PCU039335

re: Epping to Thornleigh Third Track Proposal - Application number SSI 5132

Figure 5.3 Future Cheltenham Station layout

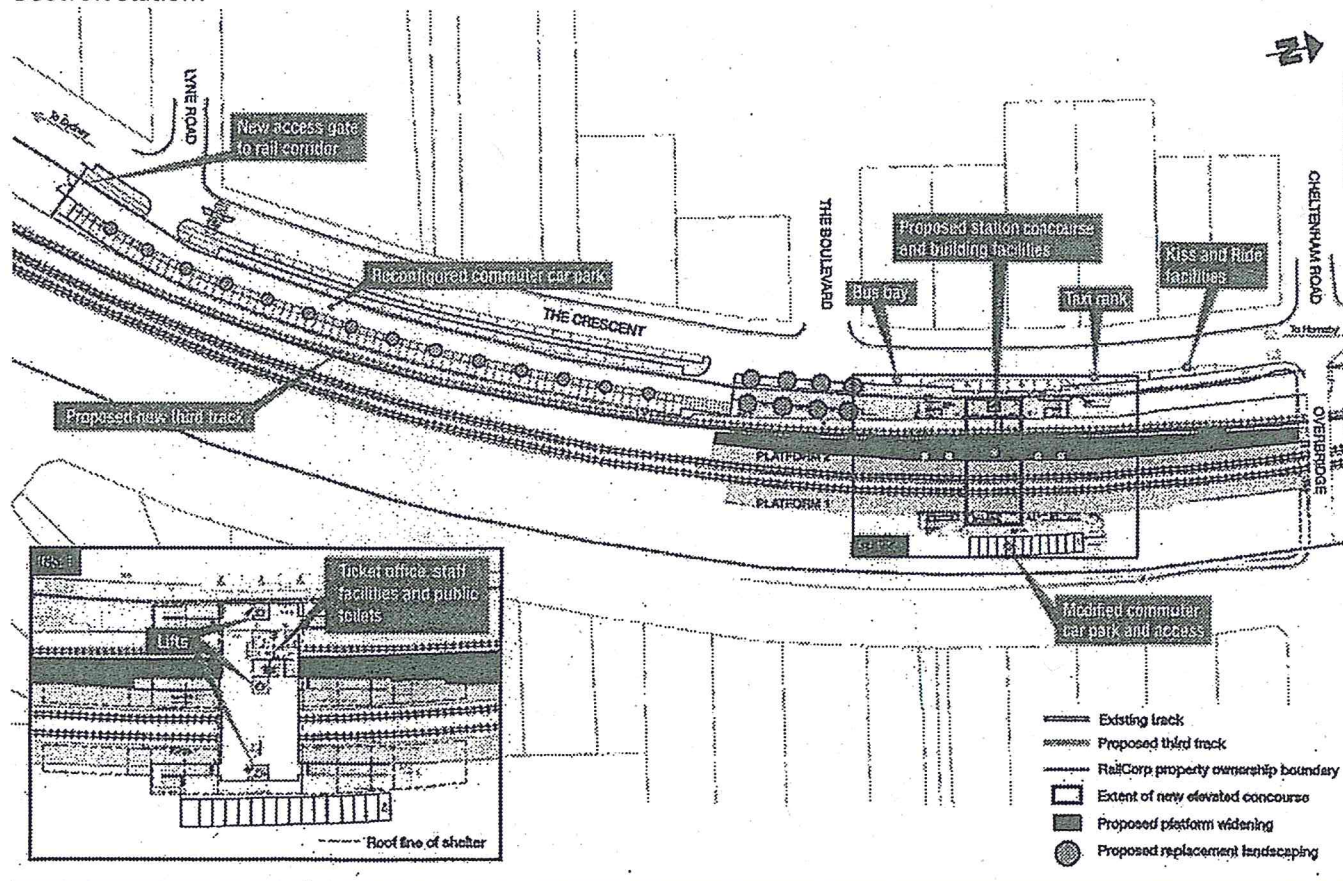
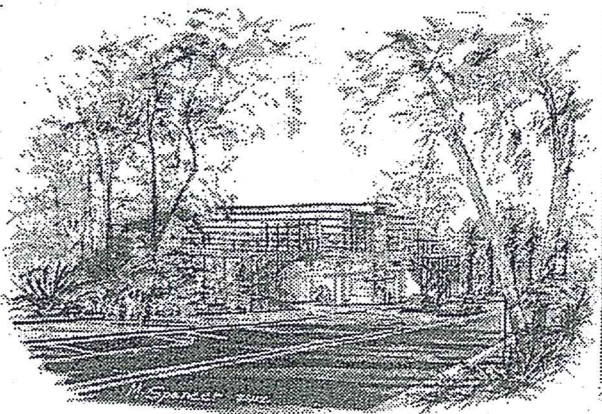
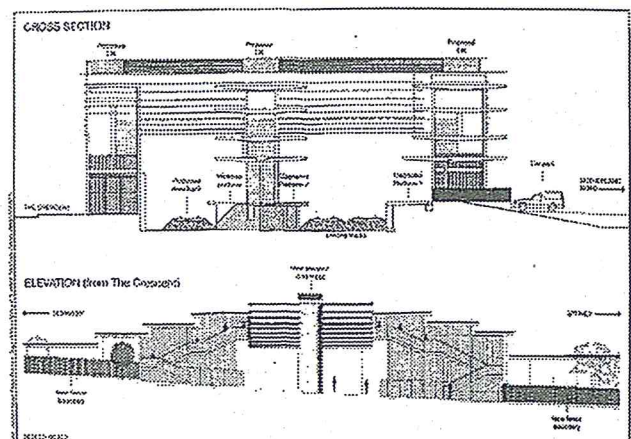
The plan for Cheltenham Station is totally out of character with the area and provision of a lift at Beecroft is not proposed but should be.

Concept design drawing of proposed changes to Beecroft Station (Parsons Brinckerhoff 9/3/12). Former side platform shaded in pink.

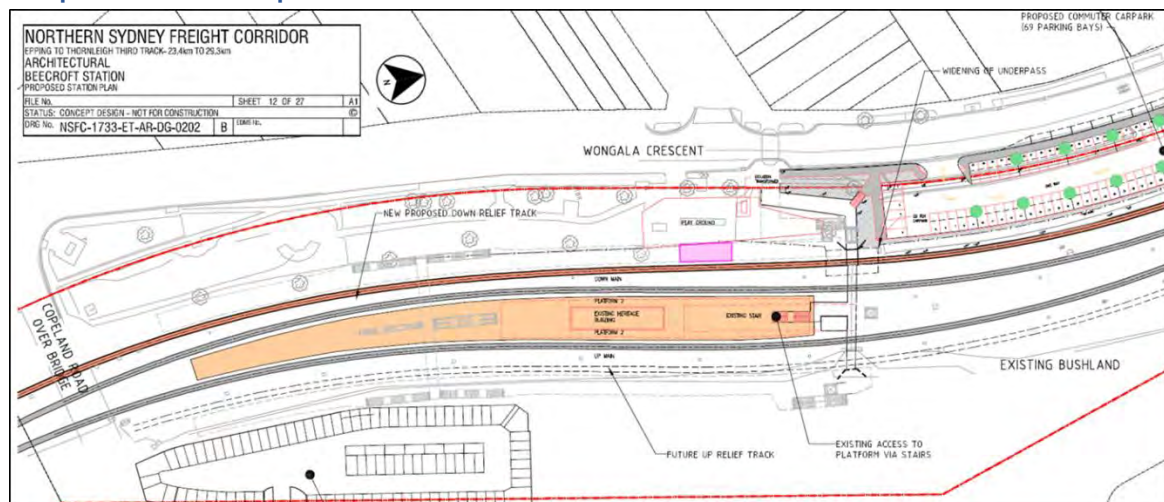
The interference with the original Beecroft platform is a concern as is the intrusion into the gardens and playground. I didn't get a understanding of what is proposed around Beecroft station. I am also concerned about how close the third line will be next to Yarrara Road at Pennant Hills Station.

Details of the engineering structures, their finishes and how they are compatible with the Beecroft Cheltenham Heritage Conservation Area need to be defined.
